RE: Third party appeal against decision of Kildare County Council

Planning Authority: Kildare County Council

Planning Register Reference: 25/61119

Development: Railpark Large Scale Residential Development, Maynooth, Co. Kildare

Figure 3.1: Western Boundary Treatment Drawing

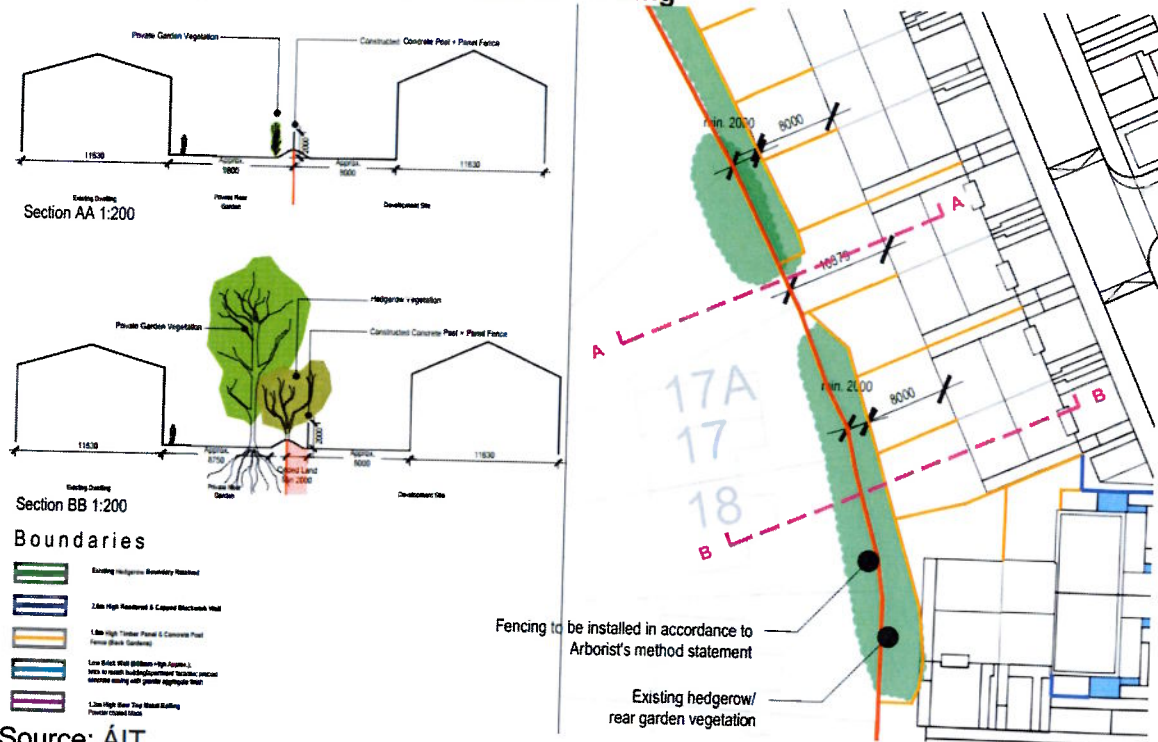
Particular concern arises in relation to numbers 22–25 Parklands Place, where the approved layout places a new road and footpath directly beside the rear boundaries of these homes. The Residents Association submission identified that the absence of a robust physical boundary treatment would result in increased exposure to pedestrian and vehicular activity and would diminish privacy and residential amenity.

The approved scheme relies largely on the retention of the existing hedgerow as the boundary between the proposed development and adjoining residential properties.

The retention of the hedgerow is supported and should be encouraged for biodiversity reasons. However, a hedgerow is not a substitute for a permanent residential boundary. While it provides ecological benefits and supports wildlife movement, it is not designed to provide the level of privacy, separation and protection expected where existing rear gardens adjoin public roads, footpaths and open spaces associated with a large residential development.

The Development Plan specifically identifies a 1.8 metre to 2 metre solid block wall as generally acceptable and further provides that where rear gardens adjoin public open space, two-metre-high screen walls should be provided.

The circumstances contemplated by *Section 15.4.6* are precisely those arising in the current application. Existing residential rear gardens are proposed to adjoin public open space, footpaths and roads associated with a substantial new residential development. Notwithstanding this, the Planning Authority did not secure a boundary treatment consistent with the standards identified within its own Development Plan and did not provide a planning justification for departing from those standards.

The Parklands Residents Association proposed a practical and balanced solution that would retain and protect the existing hedgerow for biodiversity purposes while also providing a permanent solid boundary wall on the development side of the hedge. This would protect wildlife and habitat connectivity while also providing the privacy, security and residential amenity that existing residents are entitled to expect.
